The following concerns have been raised by Harborview Flats residents, abutters to the 133 York St Condo proposal

Concerns regarding long-term viability of green wall for privacy screening

1 SOUTH ELEVATION
A-201 SCALE: 1/4"=1'-0"

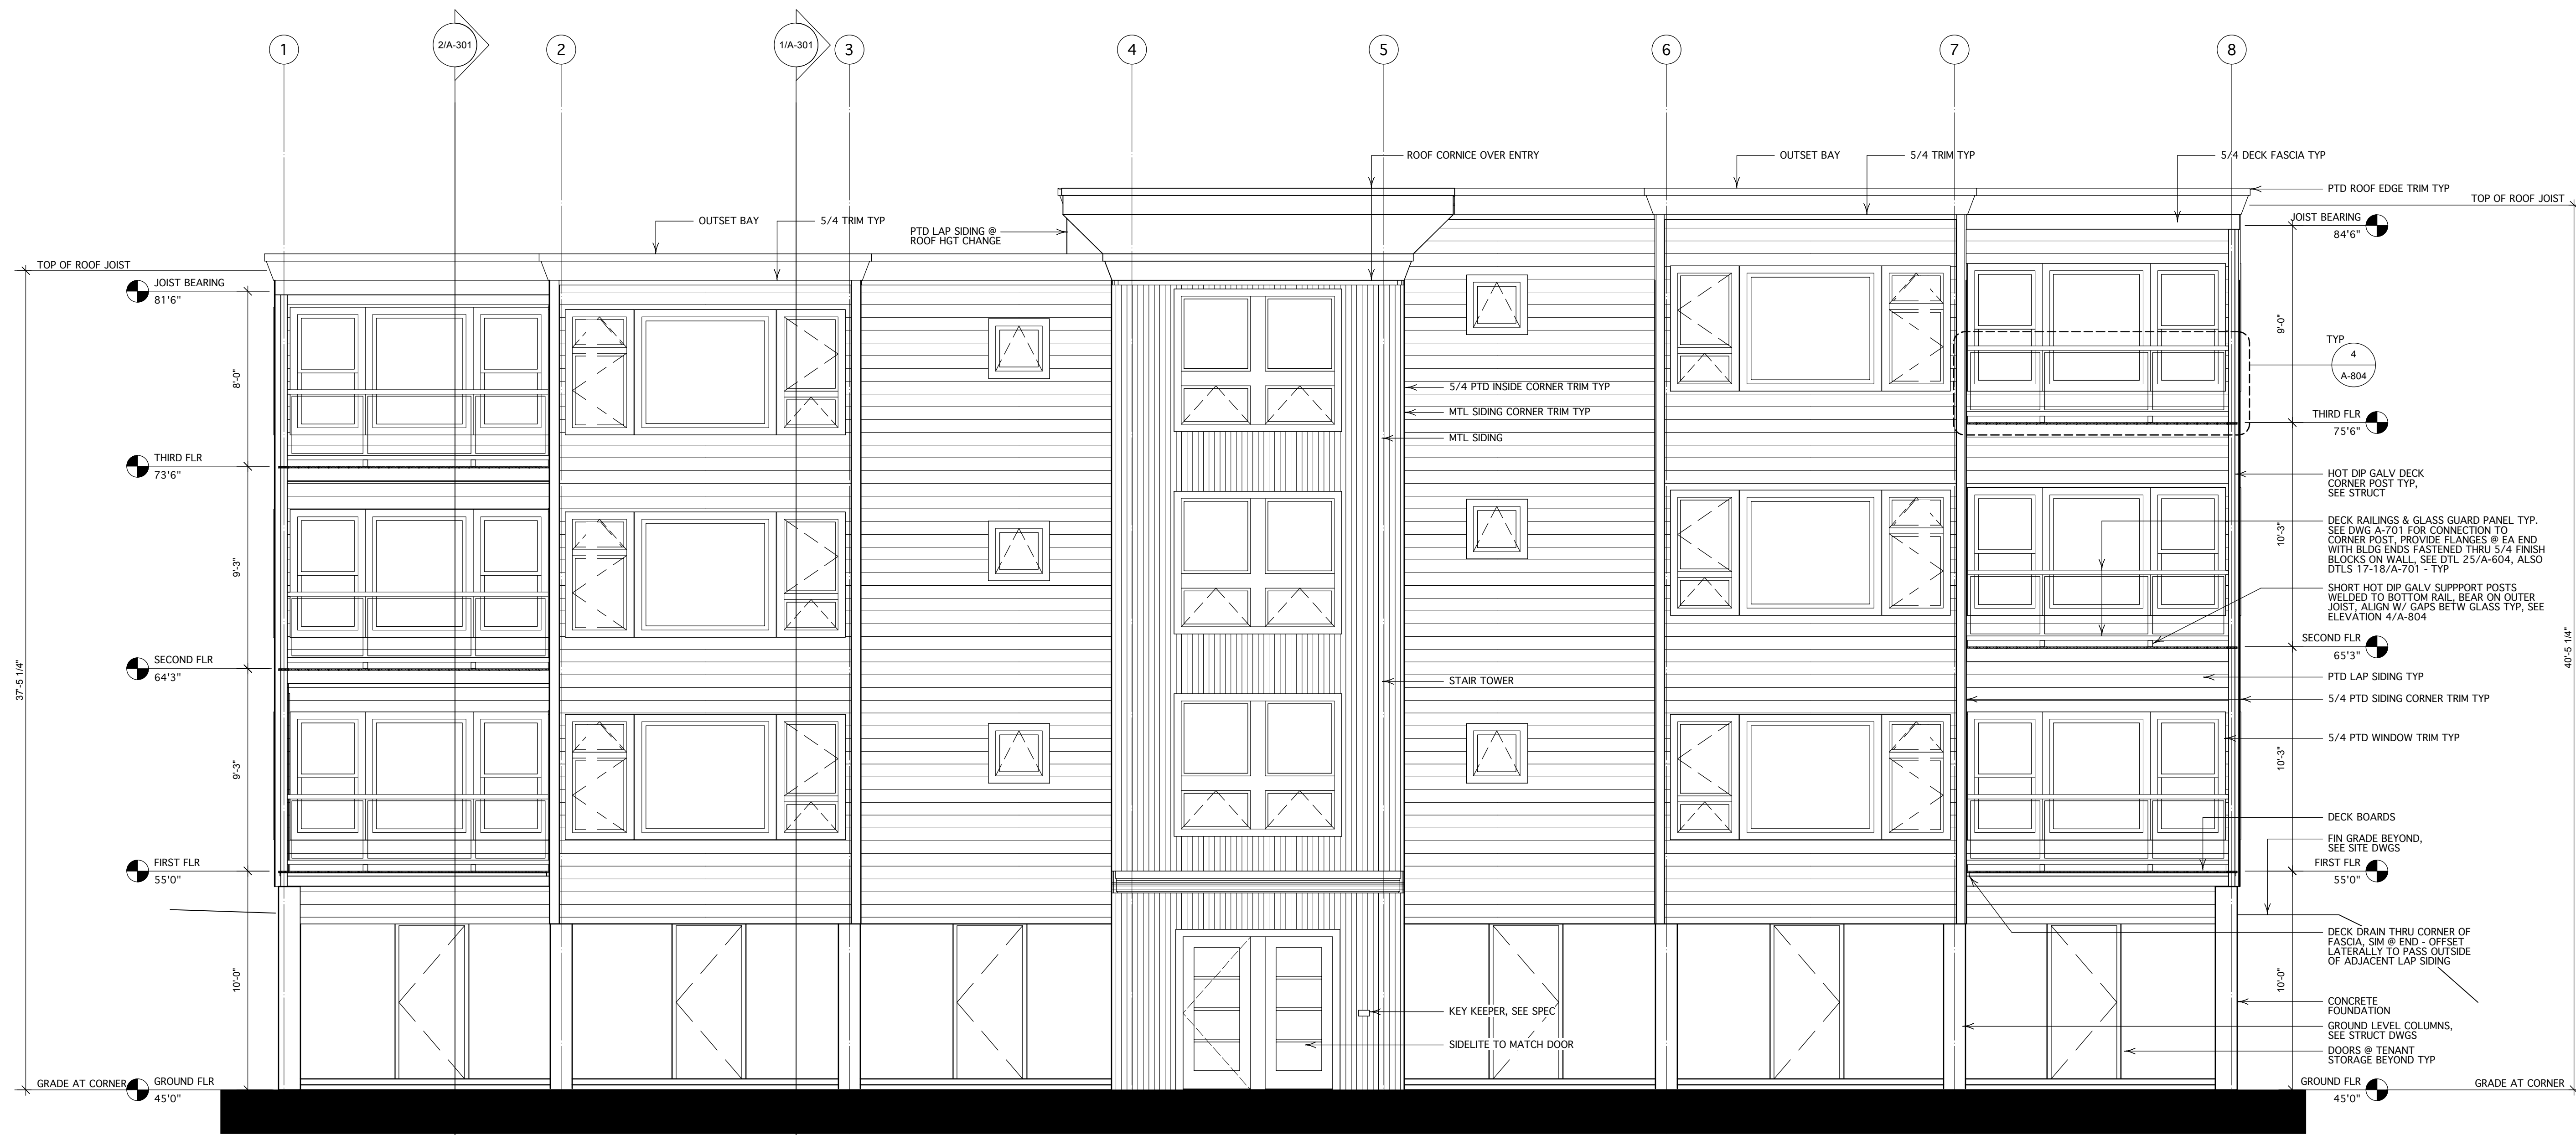
Having read the following ordinances, we are unable to see how the design below meets the conditions noted in the ordinances. This building appears to fail the criteria noted below through its lack in overall aesthetics, ticky-tacky façade, and by all appearances looks to be of questionable quality exterior materials. **In short, the design may adversely affect the property values of the abutters. The design would be much better suited to a Miami Beach affordable housing complex.**

EROSION CONTROL AND LANDSCAPE PLAN

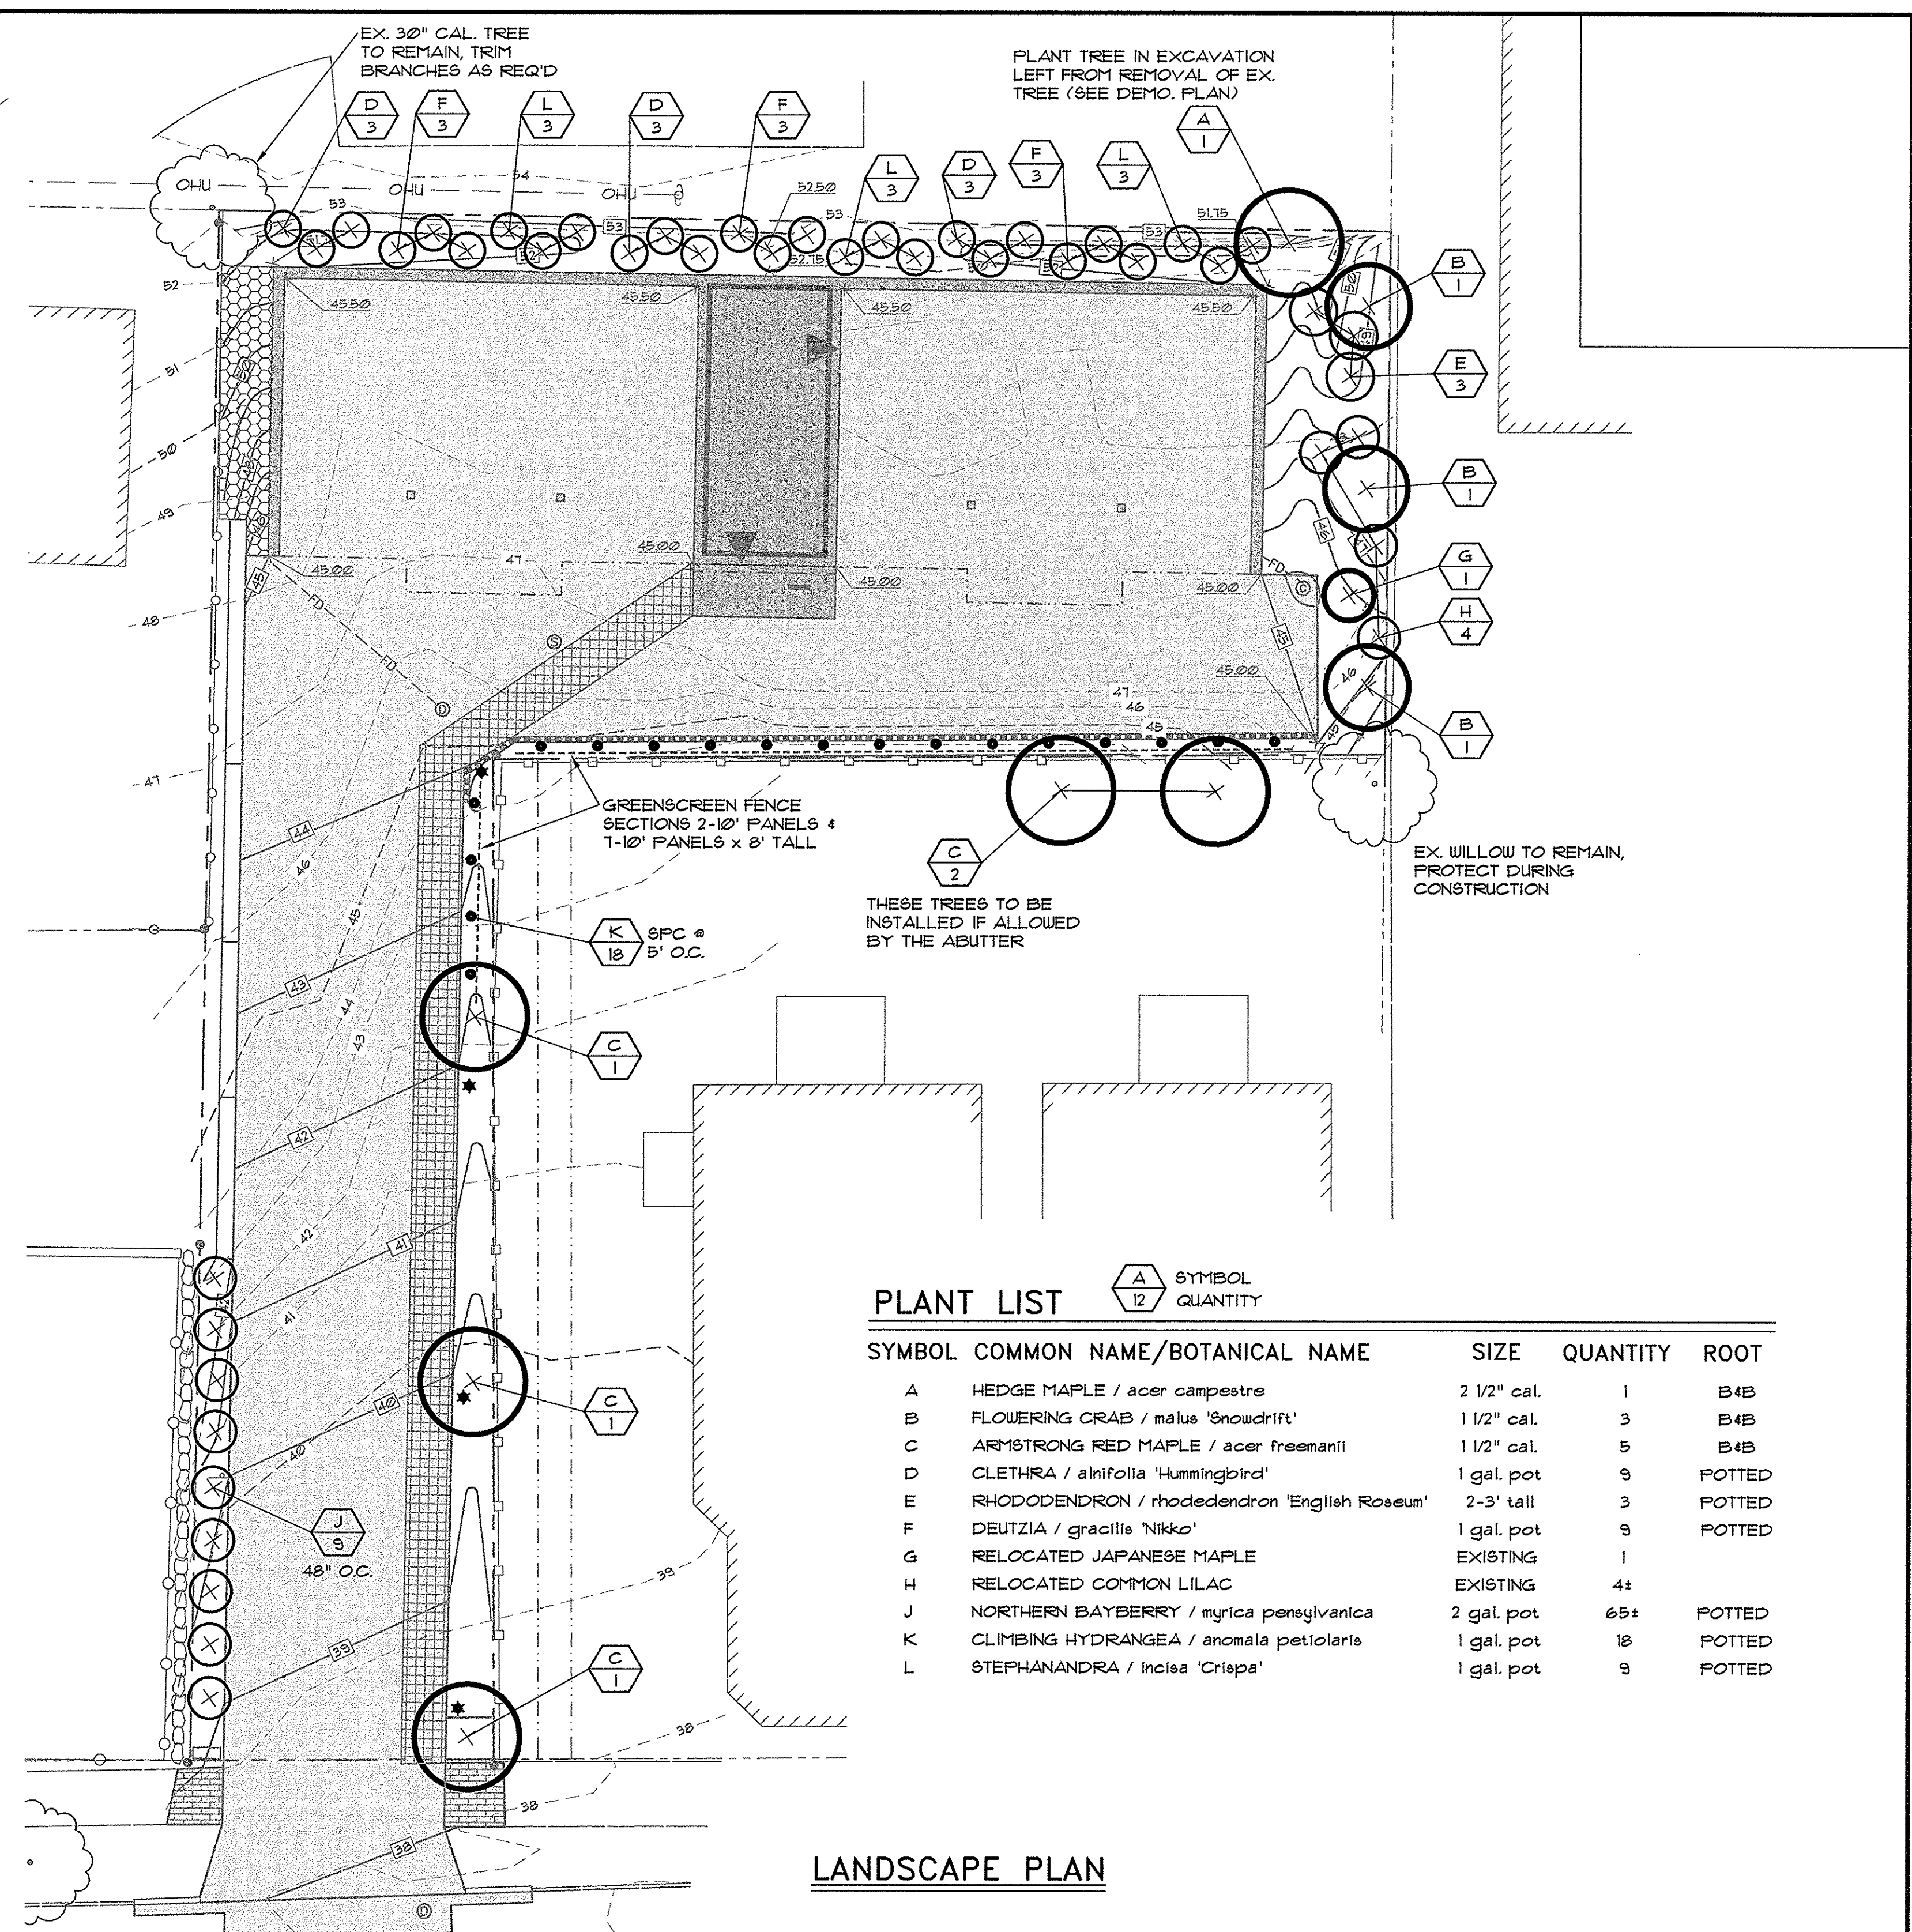
The green wall which will run the length of the Harborview Flats rear property line may be aesthetically pleasing (especially in summer months) but Harborview Flats residents have raised the following concerns:

1. A green wall may not provide the year round screening that a solid wall would provide.
2. The green wall will require long-term maintenance by the residents of 133 York to maintain any modicum of privacy for the Flats' residents.
3. It will provide less privacy screening in colder months (assuming the green wall is healthy and well maintained).
4. Maintaining a healthy green wall is unenforceable, leaving the Harborview Flats residents with no privacy and no recourse.
5. Looking 3/5/10 years into the future, Harborview Flats residents have raised serious concerns that a green wall is a poor long-term solution for sustainable long-term privacy for the condos in the rear of our building.

6. The consensus among concerned Harborview Flats residents is that a solid fence abutting the Harborview Flats fence would be superior for providing privacy screening year round.

Note: Harborview Flats is not in favor of having trees being planted on our property as the long-term maintenance will become a Harborview Flats expense.
